Tumut Paper Mill Expansion (MP06_0159-Mod-5)
Request for Additional Information

ATTACHMENT 1

TUMUT SITE DEVELOPMENT PLAN					
DRAWN	DATE	CHECKED	APPROVED	SCALE	PROJECT
BURTONC	30/09/2021	ONEILANT	ONEILANT	1:1000	TUMUT SITE DEVELOPMENT PLAN
DRAWING NUMBER				REV	
<b>C1108-TUSTG00073</b>				02

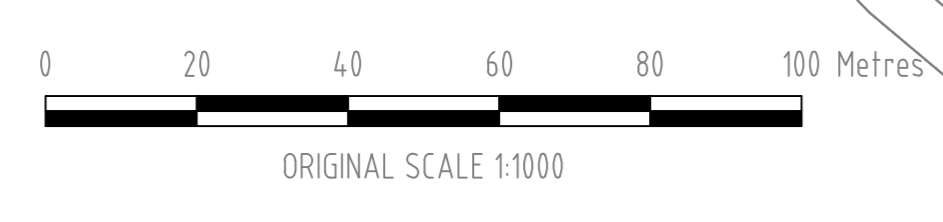
2. The Modification Report will require amendment to clearly explain that retrospective approval for the occupation of the existing storage shed is being requested and the site plan will need to be revised to clearly show the location of the existing storage shed. Elevation drawings will also need to be provided.

3. The Modification Report and site plan inaccurately references the floor area of a number of the proposed buildings and will need revision. For example, the proposed Powered Mobile Equipment Workshop will be 30 metres (m) x 16 m which equates to a floor area of 480 square metres (m²) but is referenced as 850 m².

SOUTH ELEVATION  
(NORTH ELEVATION SIMILAR)

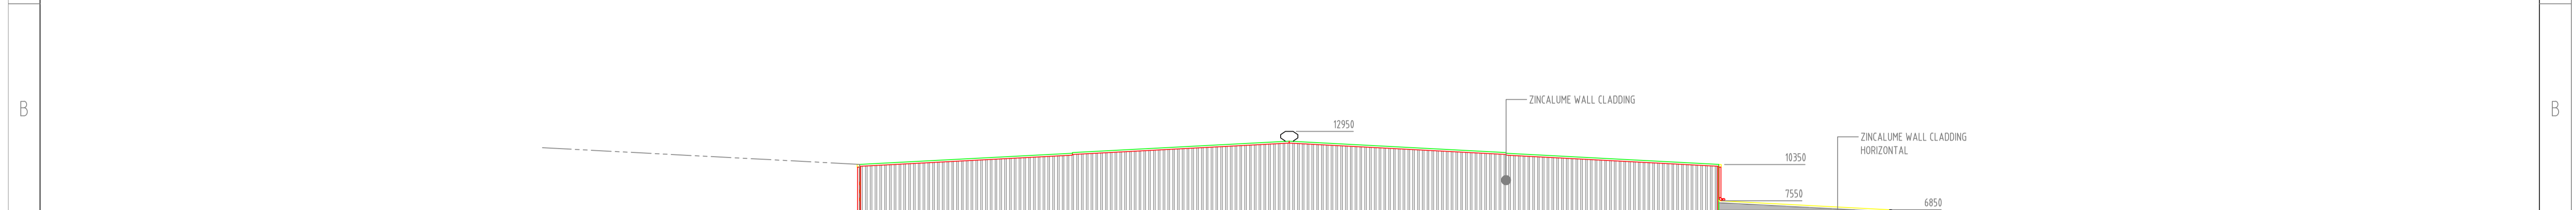
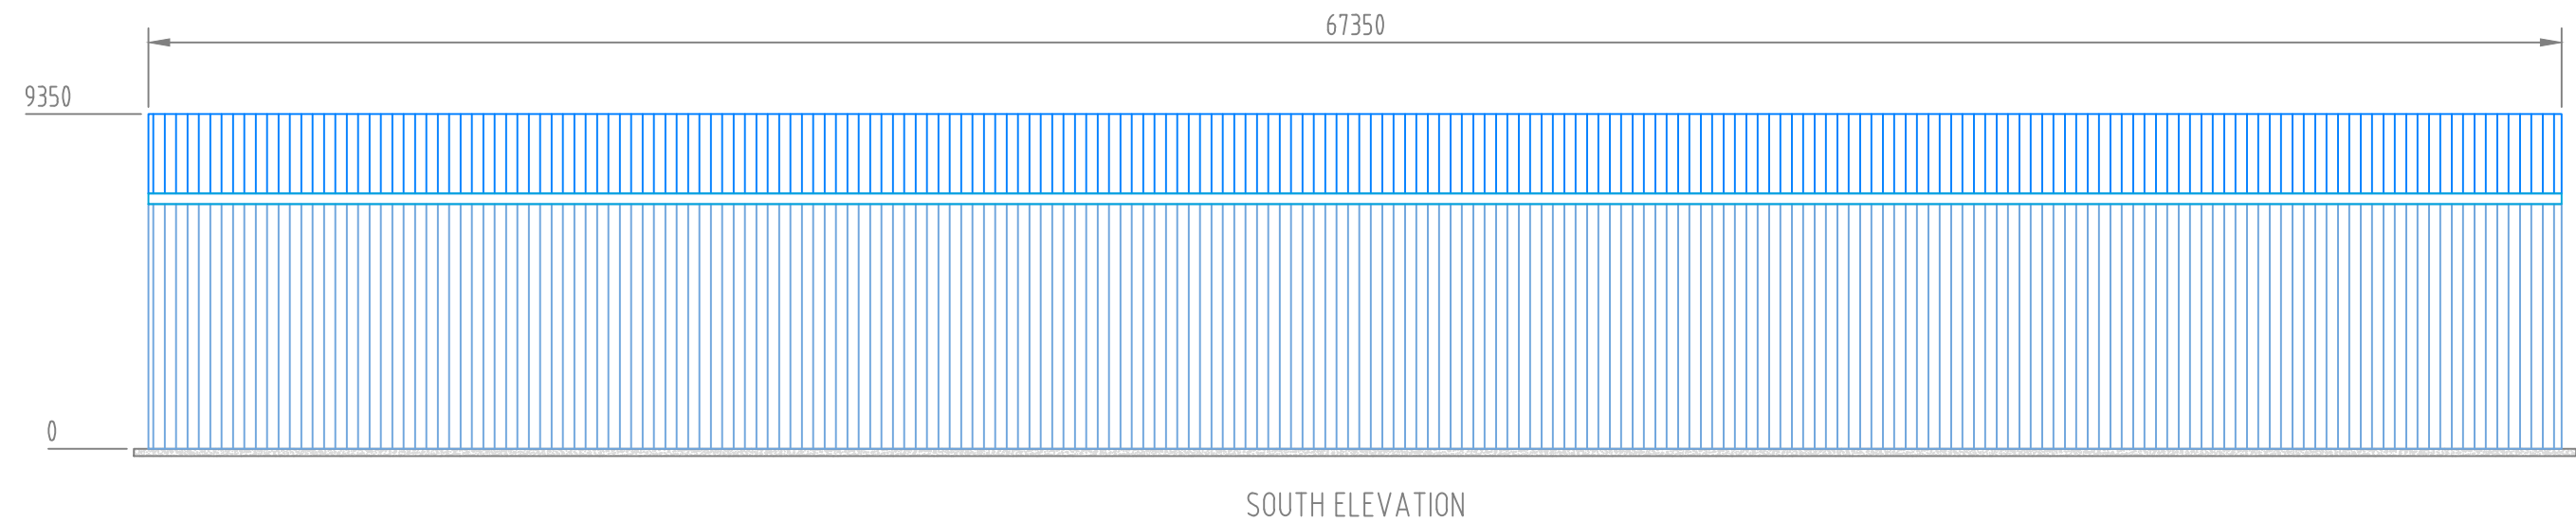
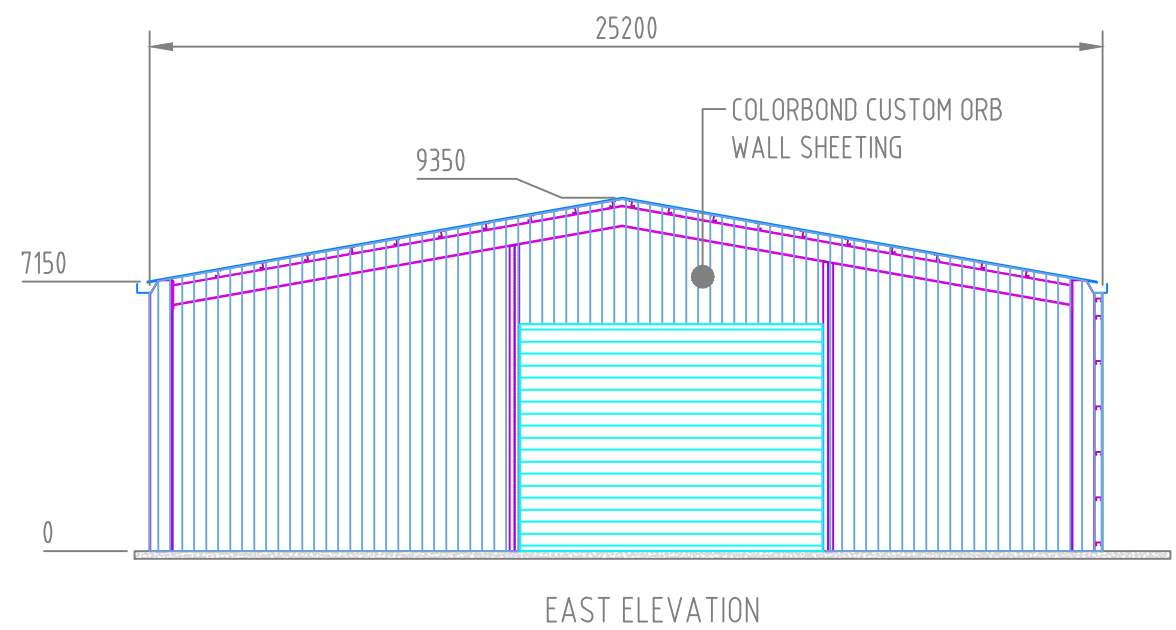
4. There is no building width provided for the proposed Reel Storage Shed on the submitted elevations and will need revision.
5. Provide confirmation that the surface area and capacity of the proposed dam are correct.

**Amenities Building / Multi-Purpose Building (ID 3#)**

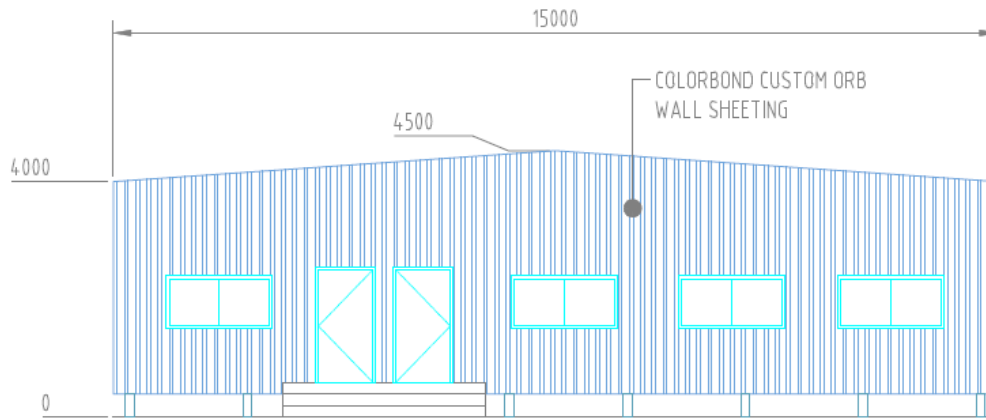
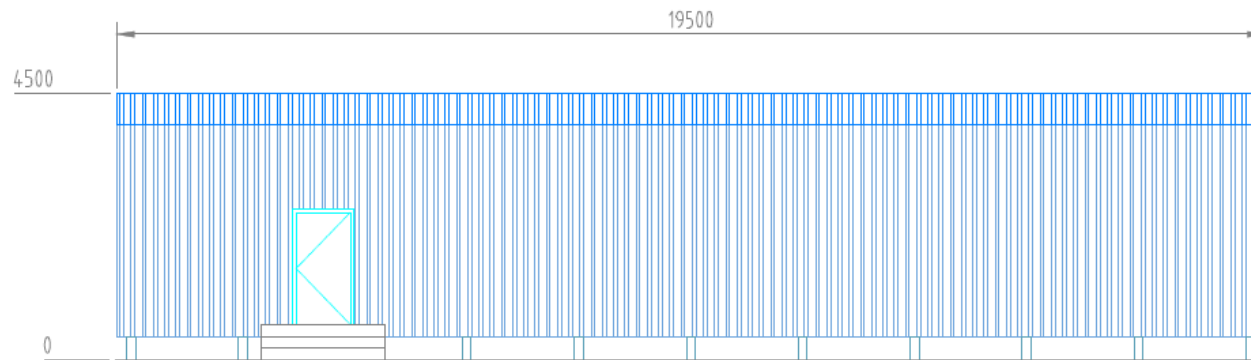
6. Describe the intended uses of the proposed amenities building.
